From: Amanda Scholes on behalf of Planning.Responses
Sent: 05 July 2017 11:20
To: Planning Scanning
Subject: FW: re- Butlins Fish and Chips restaurant application BR/98/17/PL

Additional Env Health comments

From: Nick Howard
Sent: 05 July 2017 08:38
To: Simon Davis
Subject: RE: re- Butlins Fish and Chips restaurant application

DRAWING TITLE/REVISION: Mechanical Services

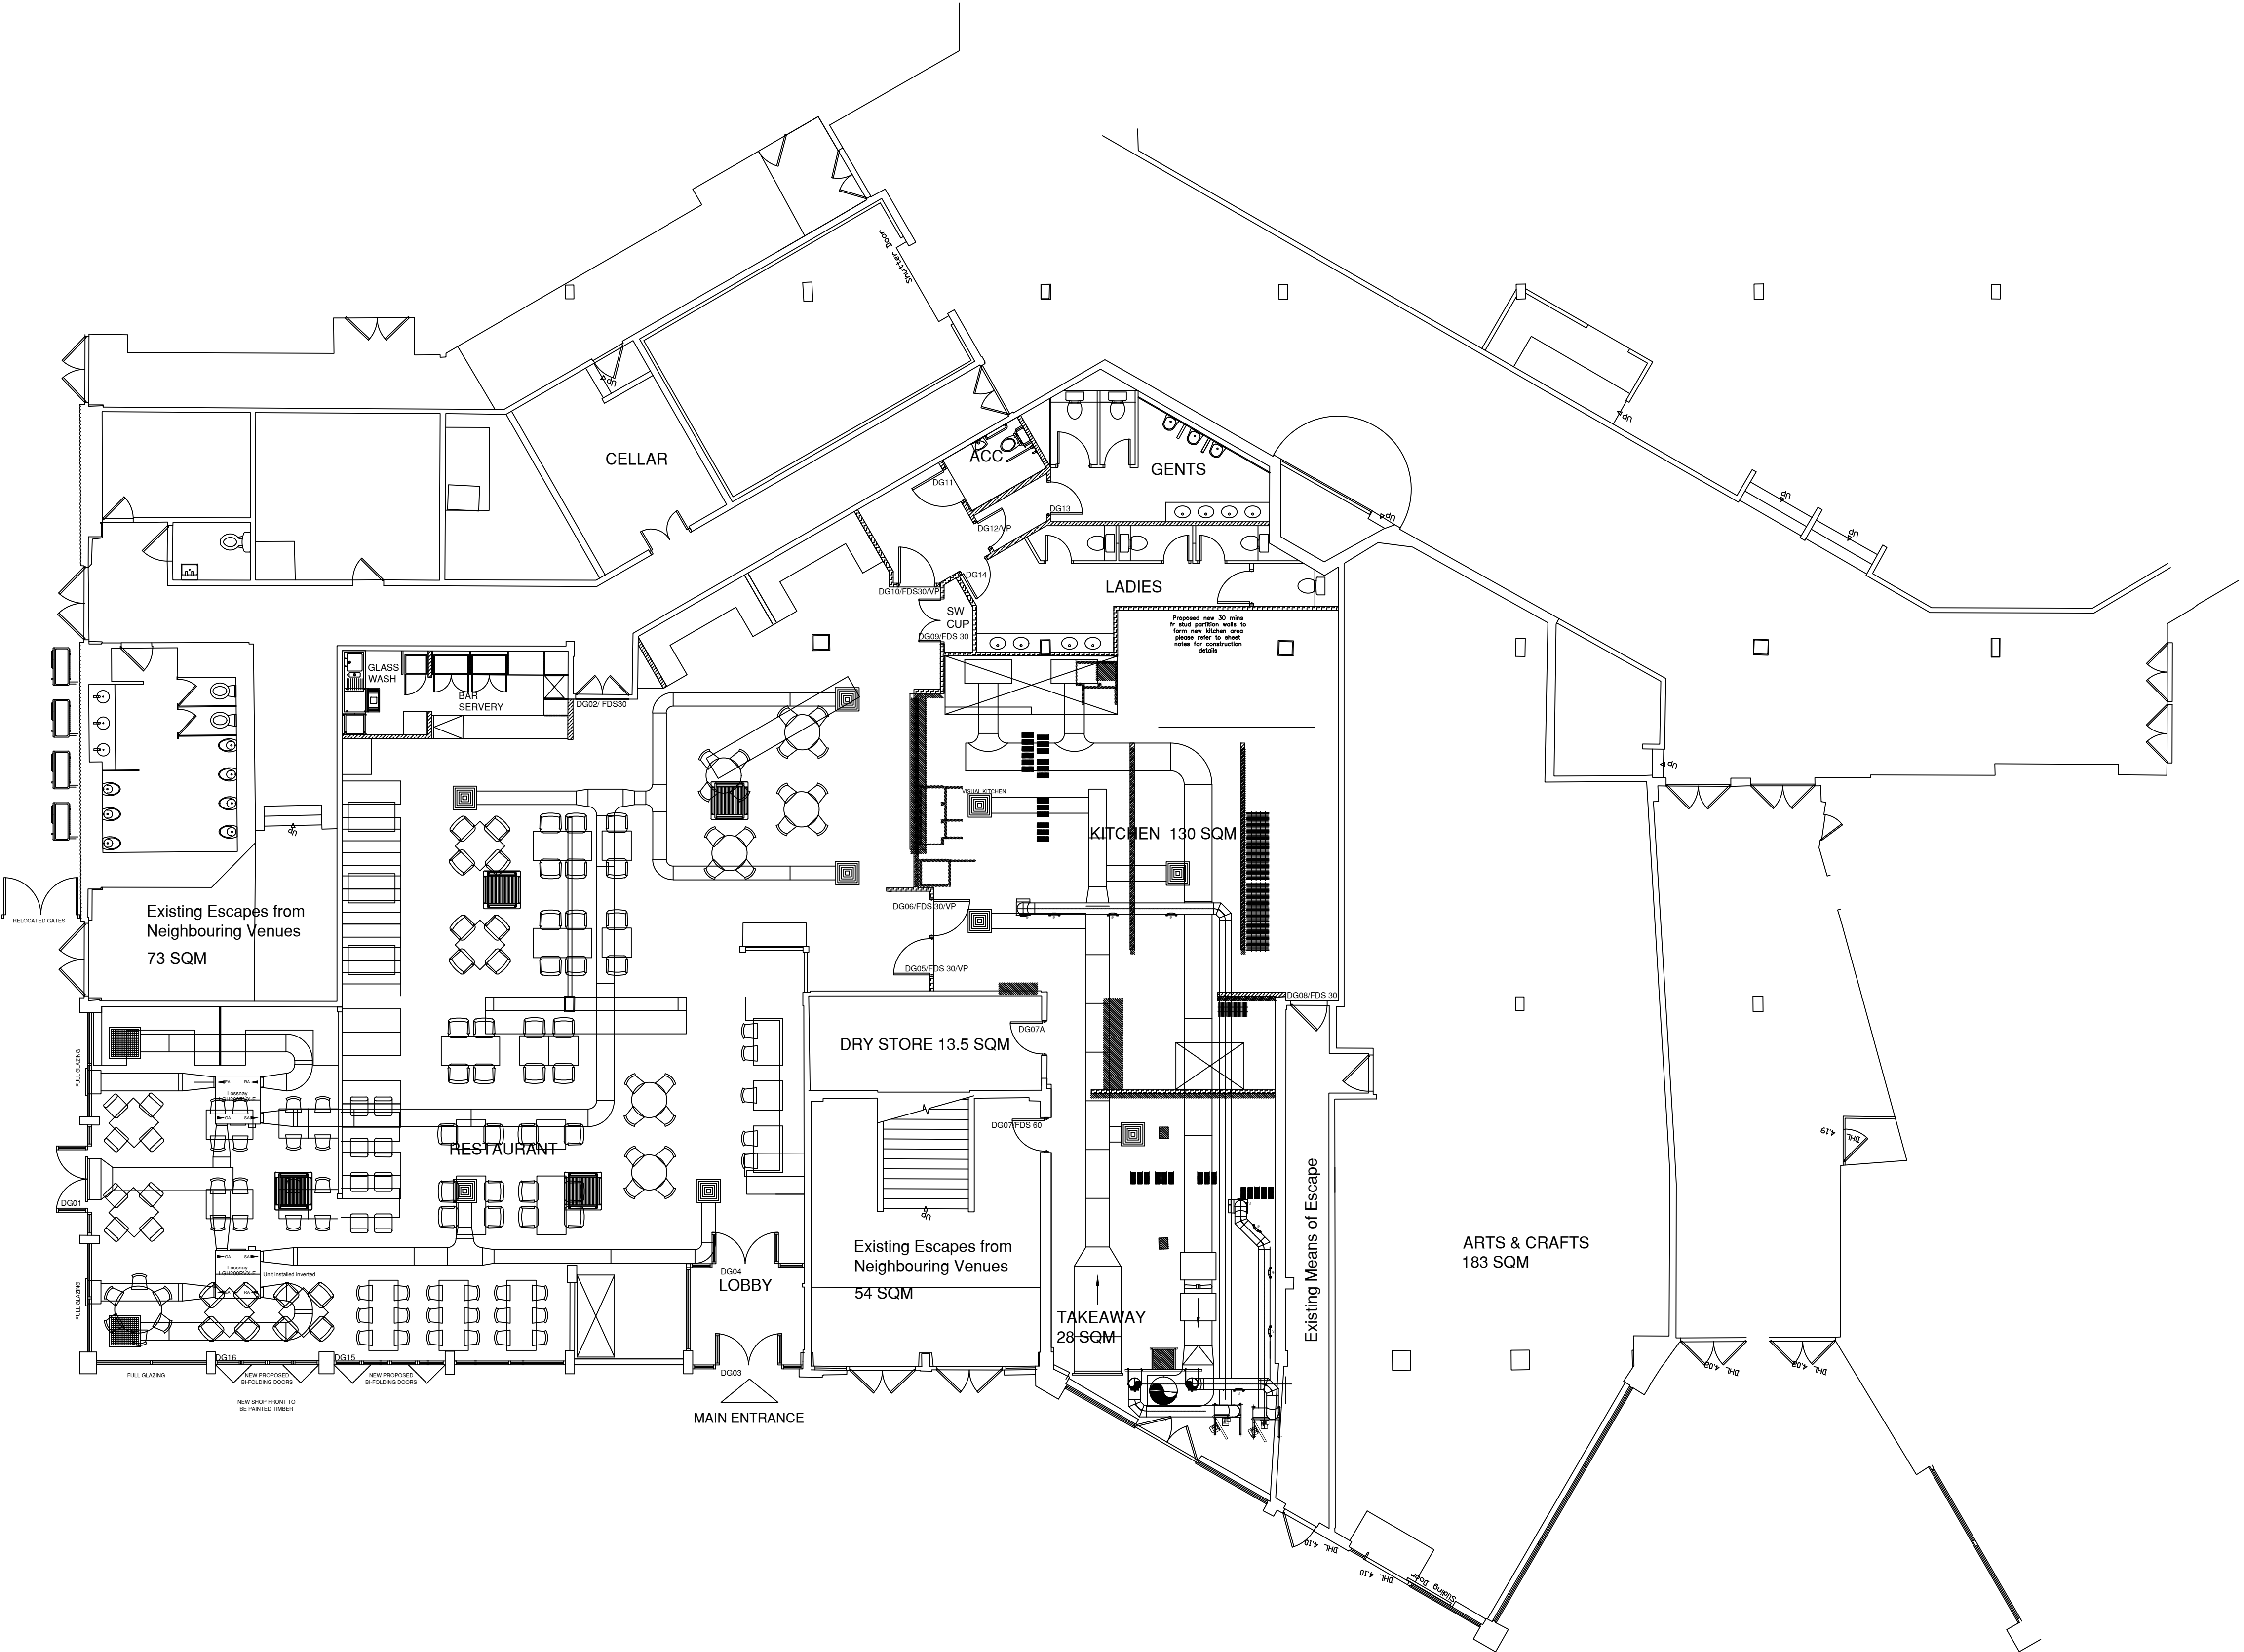
Further to my voice message yesterday I have reviewed the information again provided by Abbey and consulted the DEFRA guidance which states that such a premises would create high level of grease and odour. On my initial review of the information I could see that the baffle filters which predominantly are there to remove grease and smoke would, if working and cleaned effectively, reduce the level of grease in the canopy and duct work and hence any odour/ gases would be vented through the flue at height above the roof eaves. However reading up on baffle filters, stand alone they would not be able to address the odour. Therefore I believe that there needs to be additional controls to deal with the odour e.g's pre filters and carbon, ozone neutraliser, ESP and Ozone etc.
